**DELEGATED DECISION TO DETERMINE PLANNING APPLICATIONS TO  
CARRY OUT DEVELOPMENT WITHOUT COMPLIANCE WITH PLANNING  
CONDITIONS PREVIOUSLY ATTACHED**

Reference No:	<b>2026/70/90900/E</b>
Site Address:	Greenhill Mills, Grange Road, Batley, WF17 6LH
Description:	Variation of conditions 2 (plans) and 3 (height) on previous permission 2019/90499 for re-use footprint of former warehouse for secure external storage
Recommending Officer:	Elenya Jackson

**DECISION - REFUSED**

Project	Makin Storage Greenhill Mills Grange Road Batley WF17 6LH	01924 380873	F 2113	Scale
Drawing	Existing & Proposed site plan	Date 10/02/2026	R	1:200
		Drng No	2

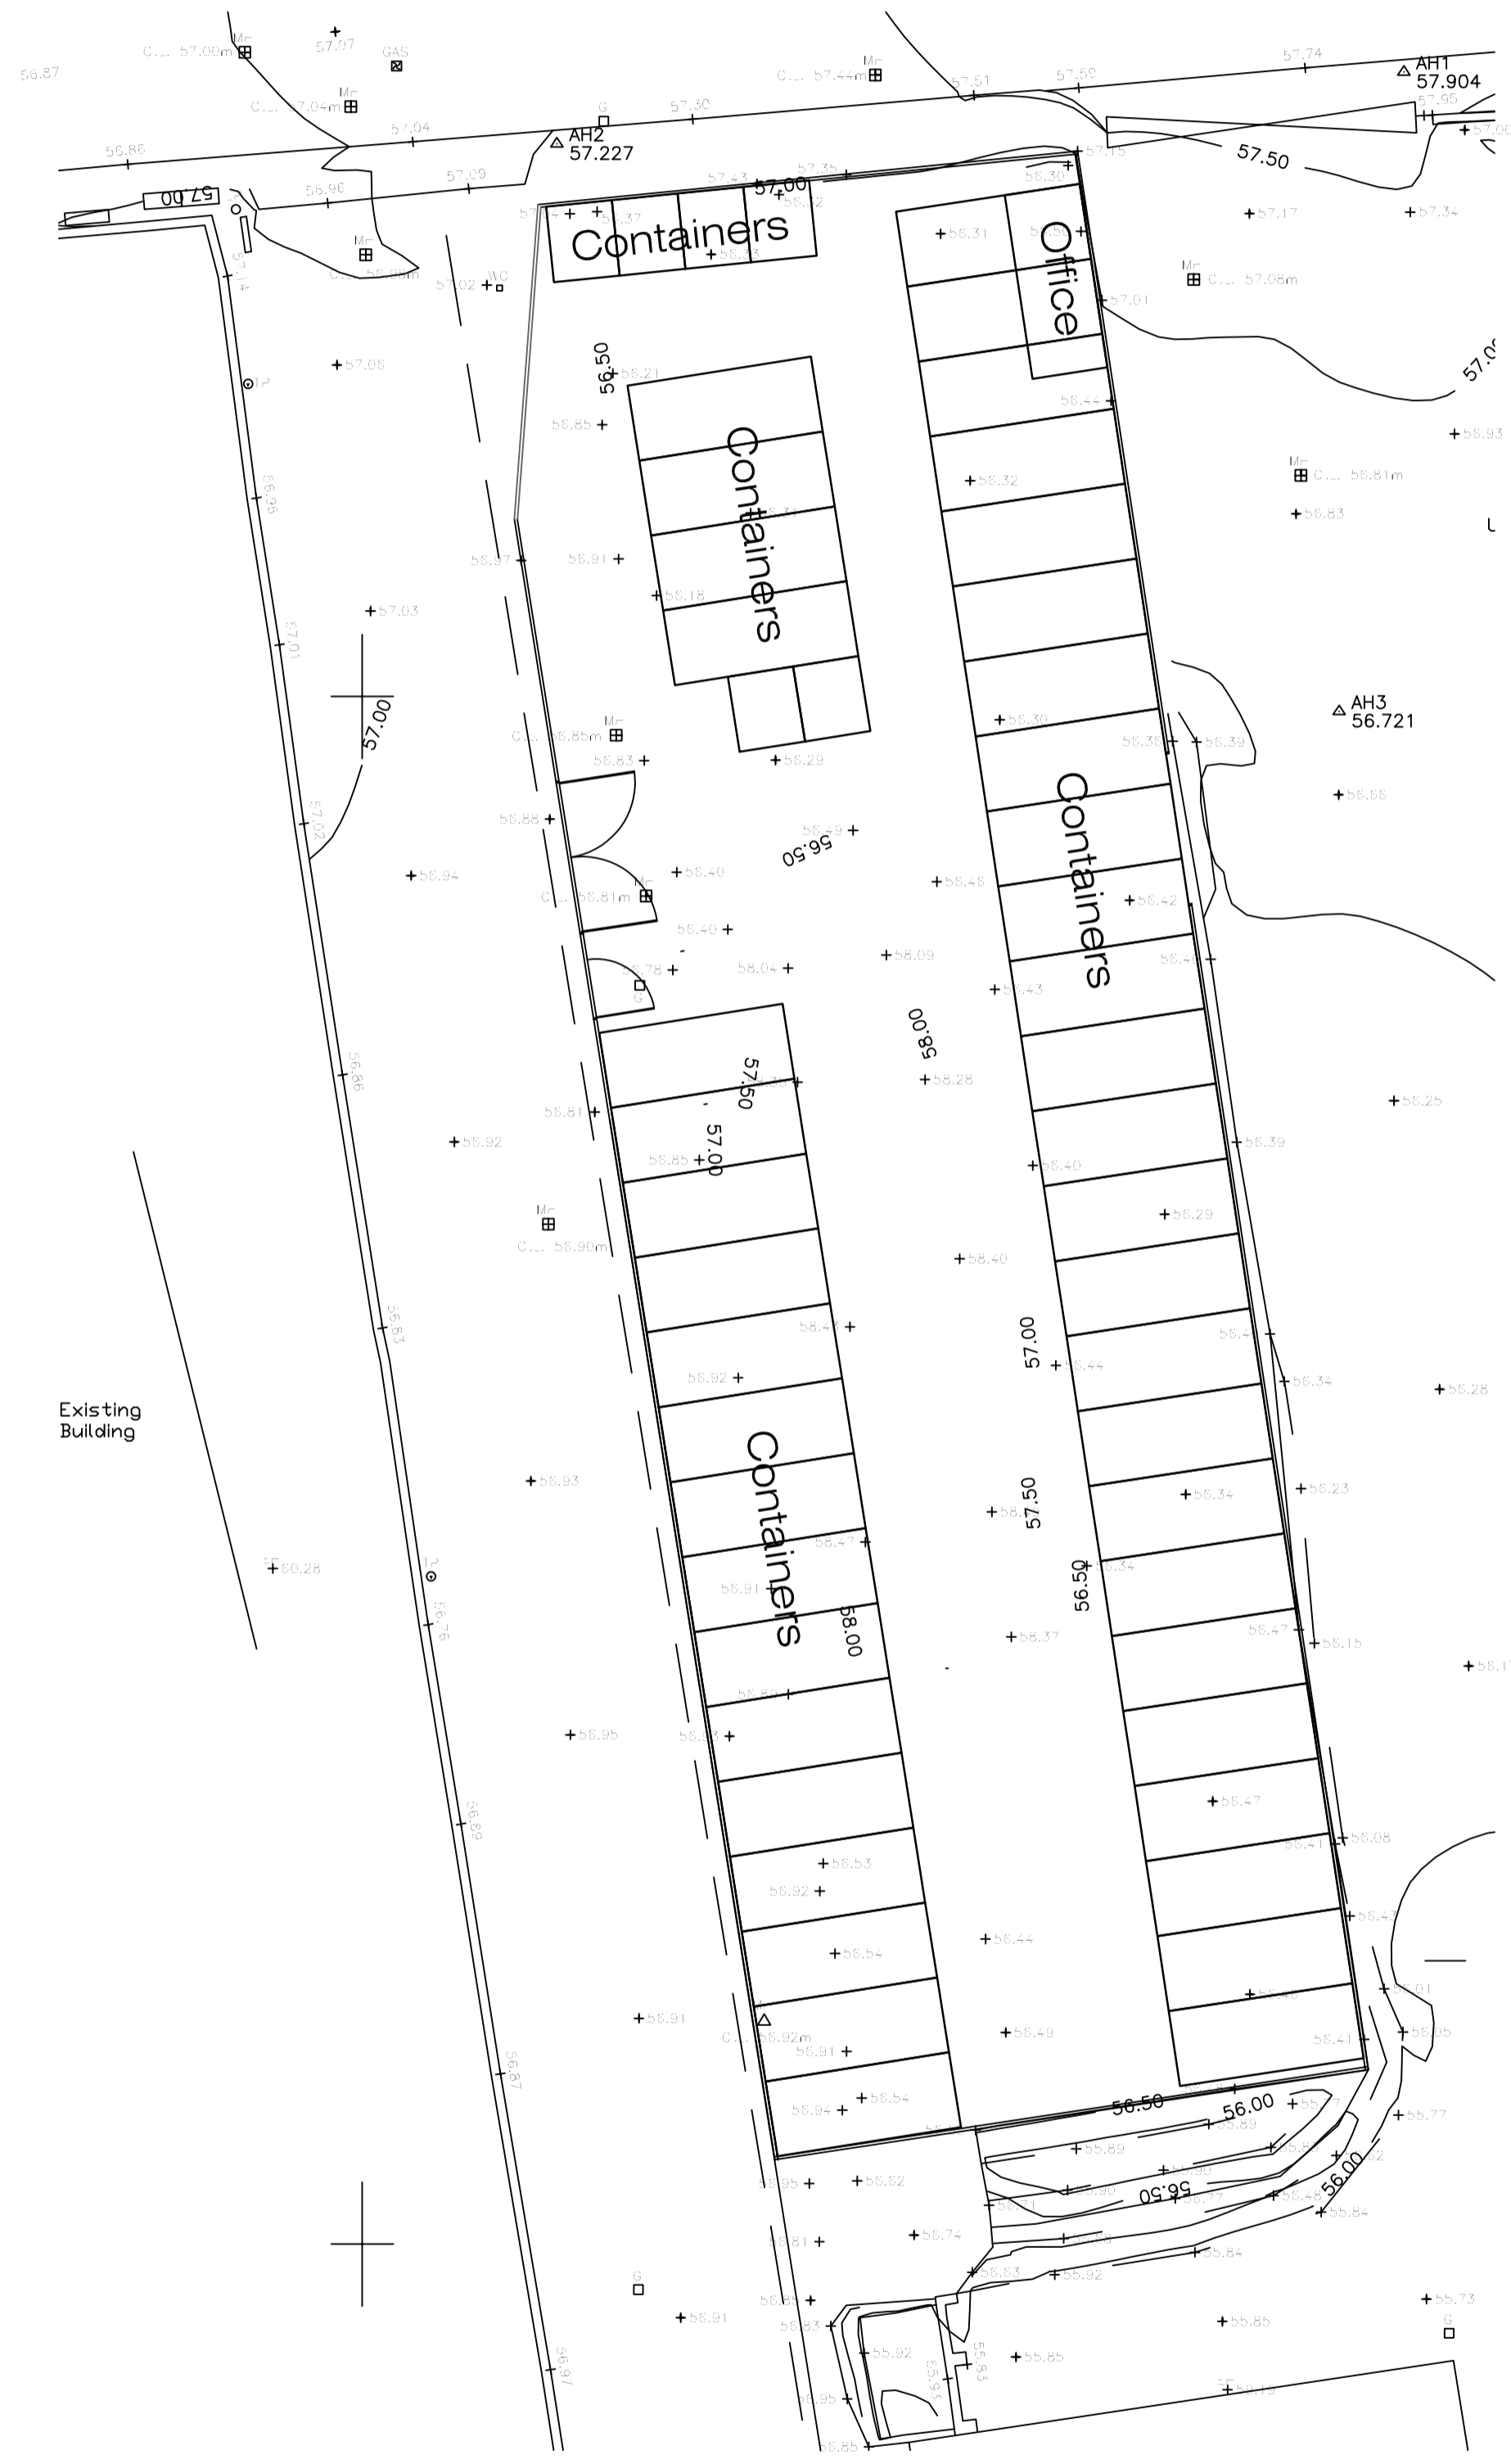
Officers have discussed the application with KC Highways and they have confirmed that, the proposed storage locations would be acceptable as they would continue the existing relationship onsite and there would still be parking provision on site.

Project	Makin Storage Greenhill Mills Grange Road Batley WF17 6LH	01924 380873	F 2113 R	Scale 1:100
Drawing	Existing and proposed elevations	Date 10/02/2026 Drg No	1

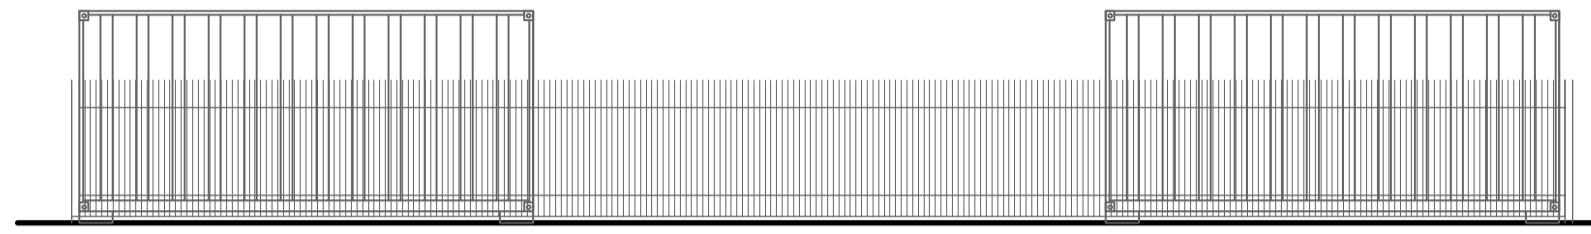
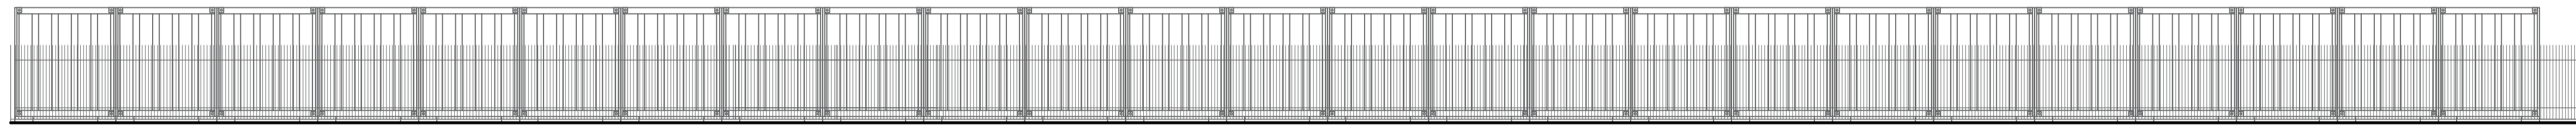
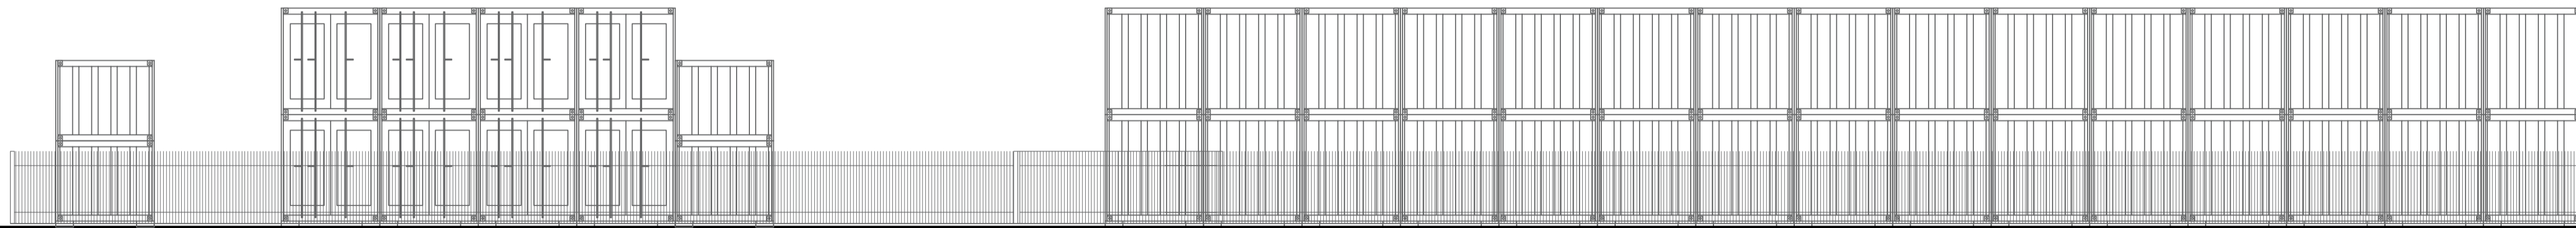
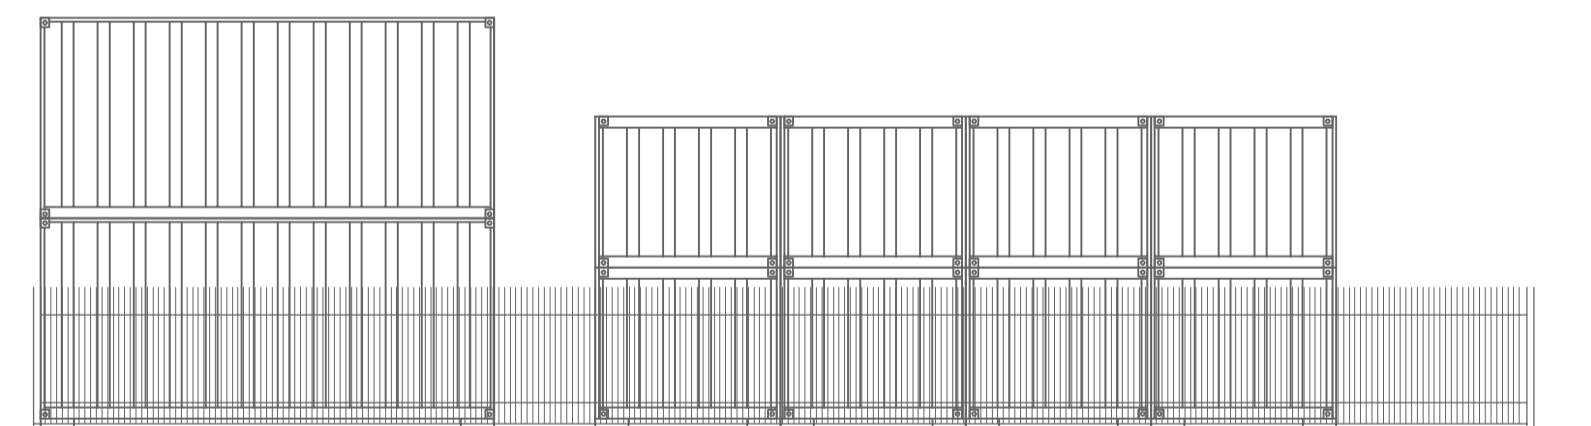
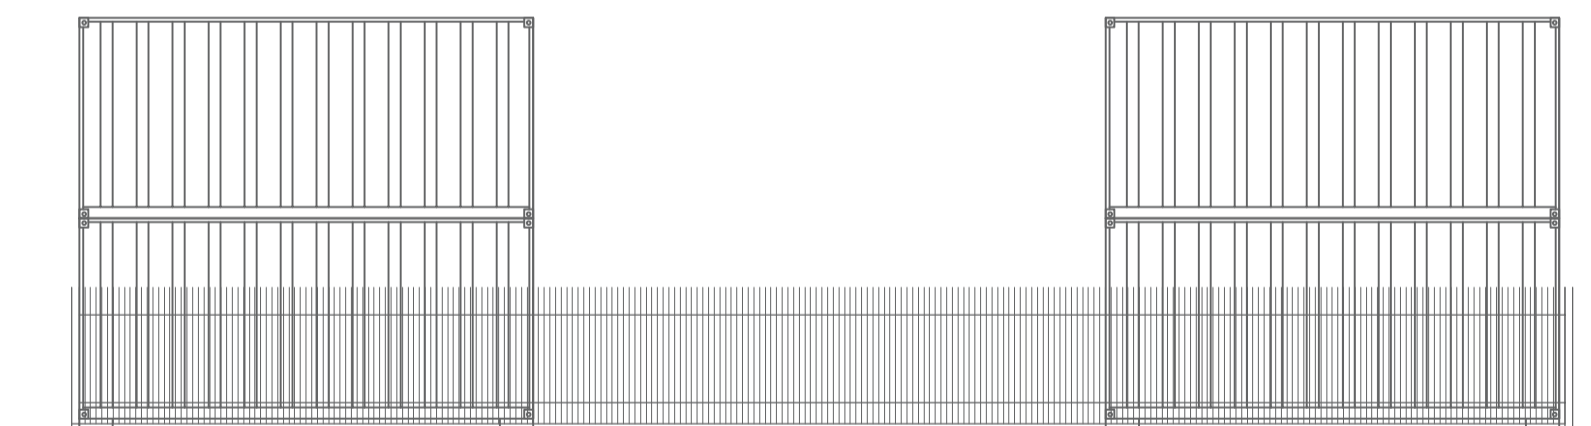
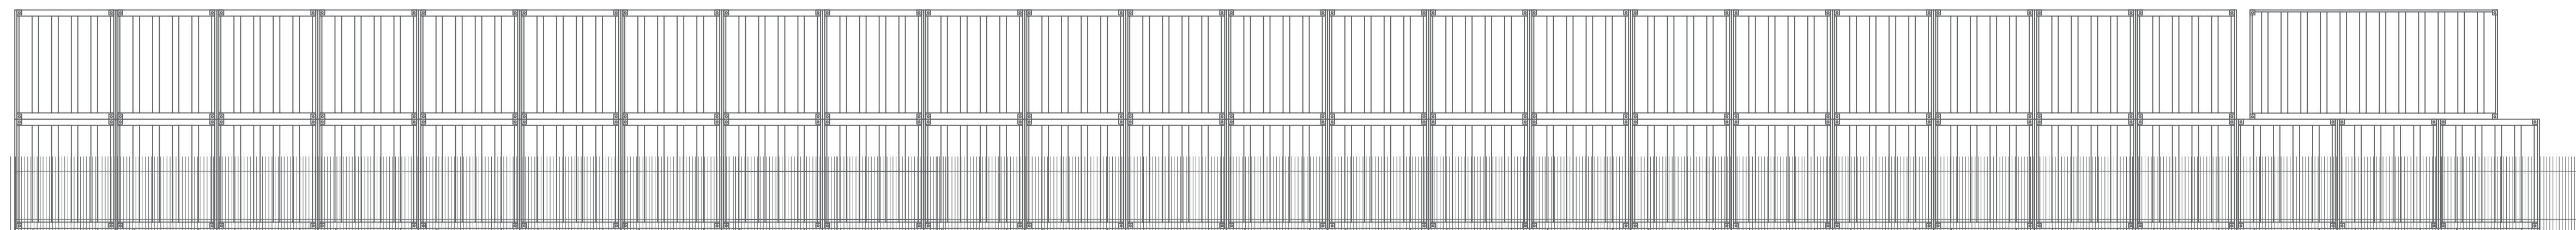
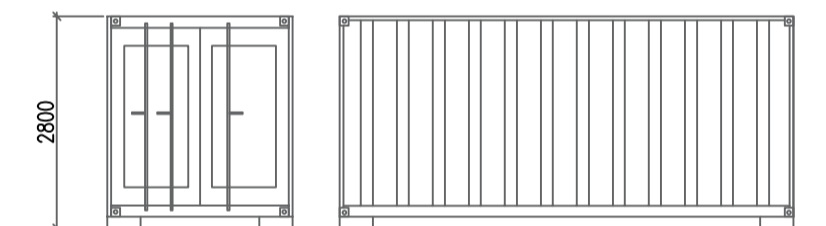
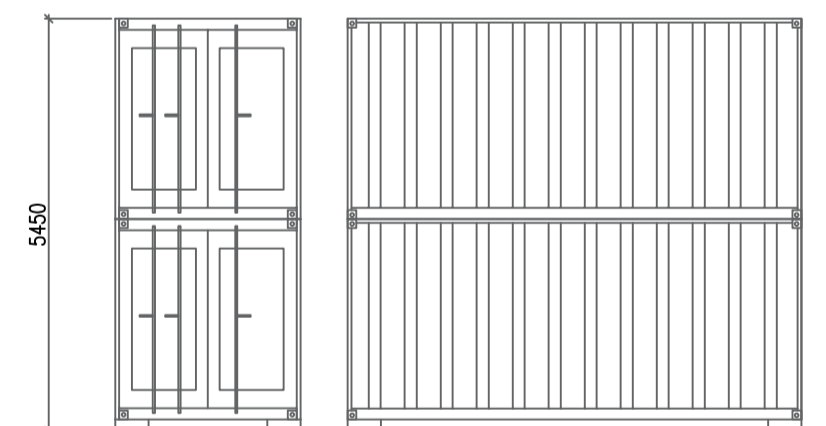
The application seeks permission under a Section 73 application to vary previous conditions. A revised elevation drawing has been provided which shows the existing and proposed elevations of the site. The submitted plan (ref: DWG 1) demonstrates the proposal would be two shipping containers high opposed to one.

The application has been supported by existing and proposed elevations which demonstrate the increase in scale of the external storage, where it would be located on site and its visual appearance. It is considered by officers that the increased height of the shipping containers would increase the sites prevalence within the street scene resulting in a negative impact detrimental to the character. There is limited screening between the site and the public realm and it is considered that shipping containers would not contribute positively to the street scene.

It is considered that the increase in height of the external storage in a mixed use setting would appear excessive and run-down and would have a greater impact than the existing development.

1. The location, scale and materials along with the increased height of the shipping containers would be highly visible and significantly increase the sites prominence from the public realm detracting from the character of the street scene and wider area. The proposal would have an unacceptable impact on visual amenity, contrary to policies LP1, LP2 & LP24 of the Kirklees Local Plan and policies within Chapter 12 of the National Planning Policy Framework.
